# Markup Summary

THE SPRINGS AT WATERVIEW FILING NO.1  
A SUBDIVISION OF A PORTION OF THE NORTHWEST 1/4 OF SECTION 7,  
TOWNSHIP 15 SOUTH, RANGE 65 WEST OF THE 6TH P.M.  
EL PASO COUNTY, COLORADO  
SHEET 1 OF 2

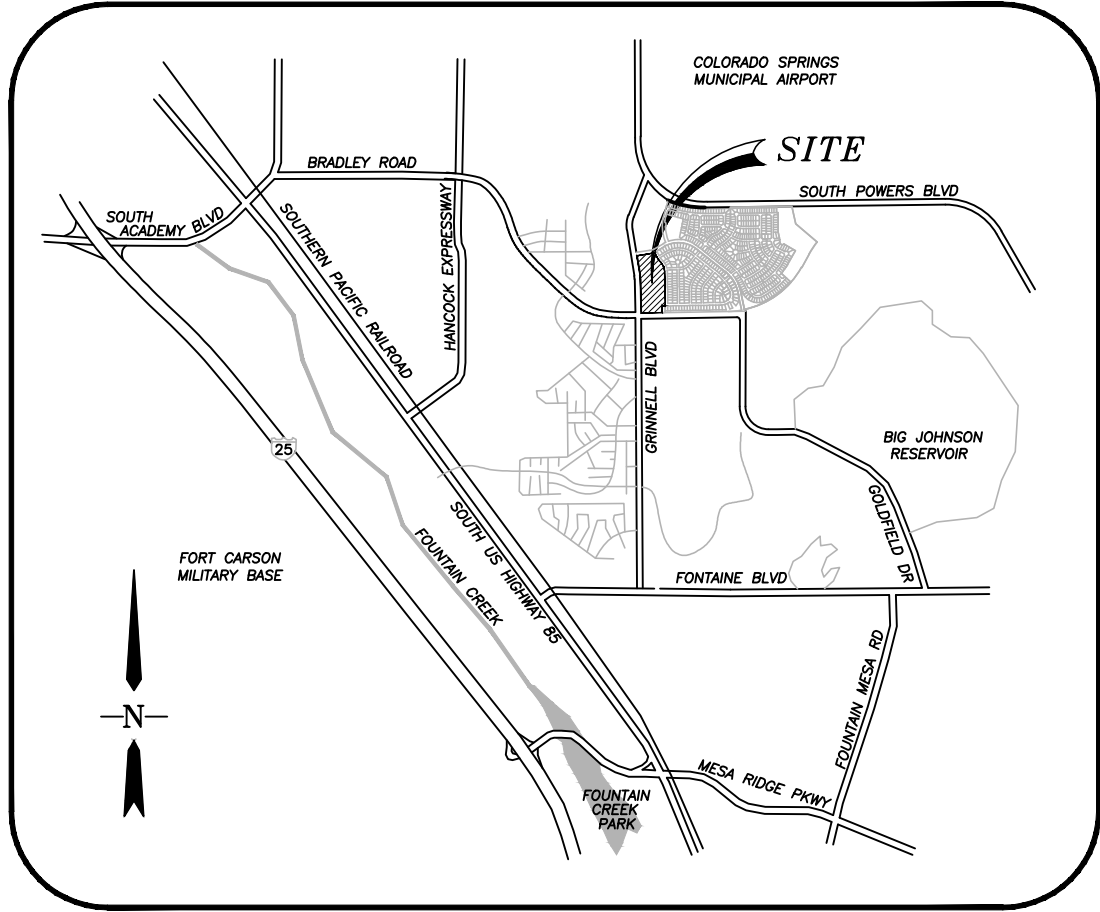
19. Mailboxes shall be installed in accordance with all El Paso County and United States Postal Service regulations.

There shall be no direct lot access to Grinnell Blvd, Bradley Road, Goldfield Drive, and Escanaba Drive.

Resolution 16-454, Reception No. 216145945

Clarify this will be for future owners/builders

Add file number

Take note of new department names and the president vs chair

Add a note vacating existing plat

A SUBDIVISION OF A PORTION OF THE NORTHWEST 1/4 OF SECTION 7,  
TOWNSHIP 15 SOUTH, RANGE 65 WEST OF THE 6TH P.M.  
EL PASO COUNTY, COLORADO  
SHEET 2 OF 2

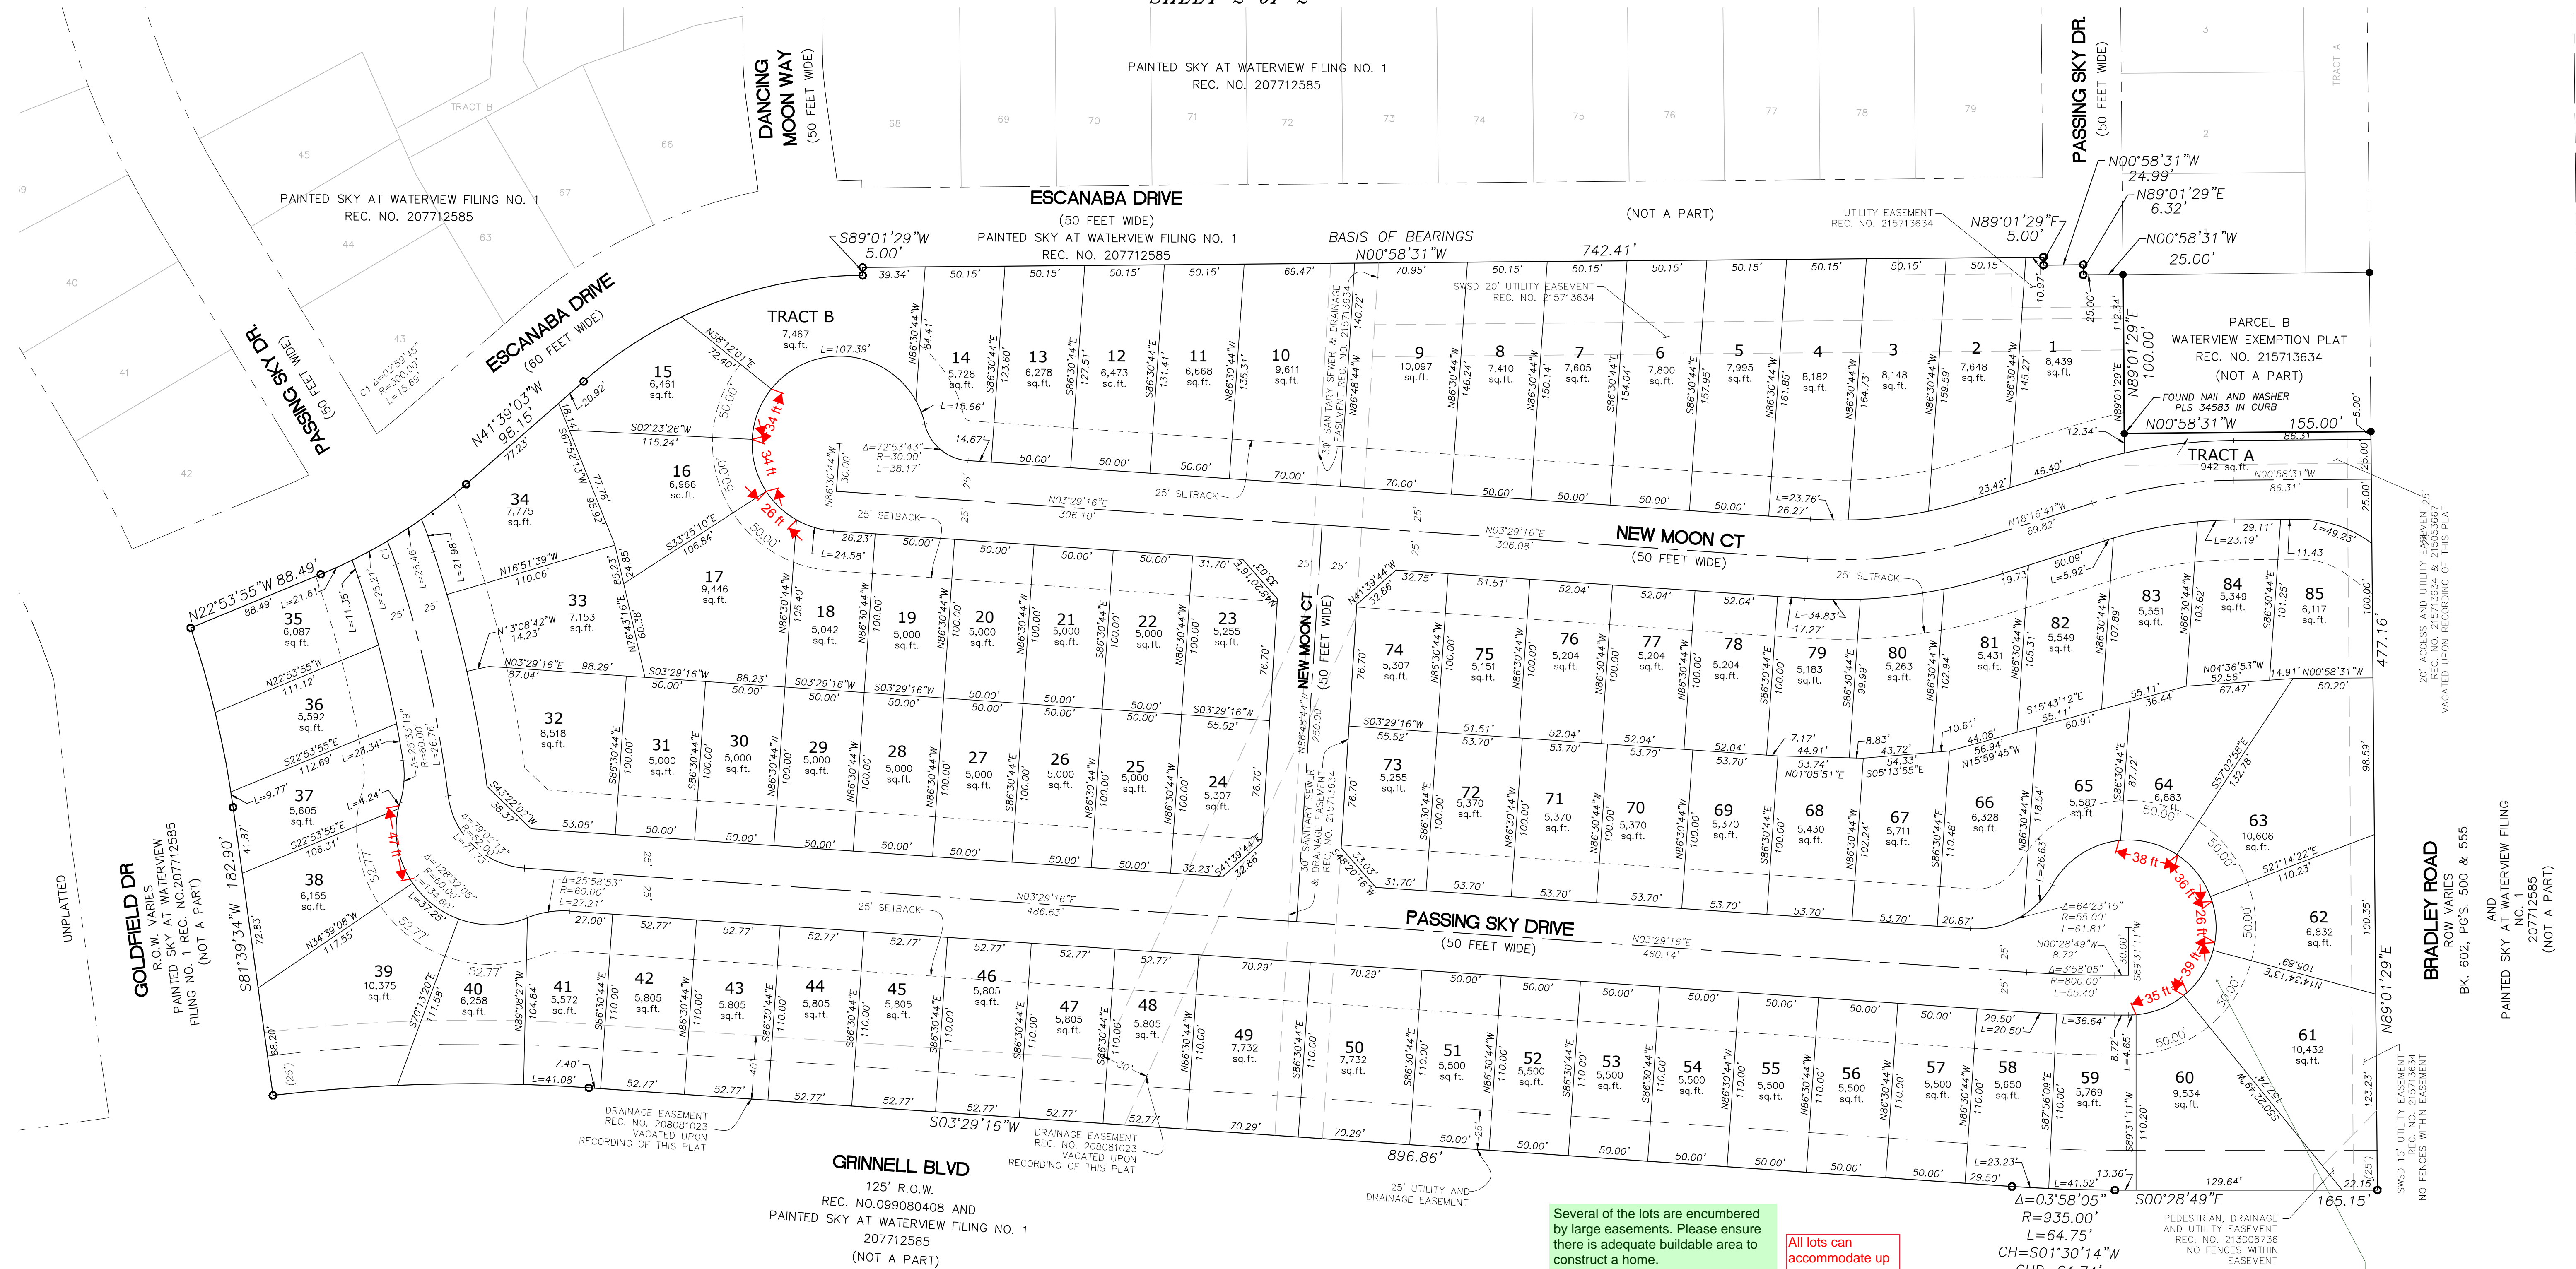
Clarify that fencing can't be built within this easement.

The construction drawings does not show the existing sewer line as being removed and relocated.

add a note referencing this easement and if structures may be placed on top of it.

Add setback line showing where lots are 50' in width for those that are not 50' at the boundary.

Please move, the line is difficult to read when on top of the other.
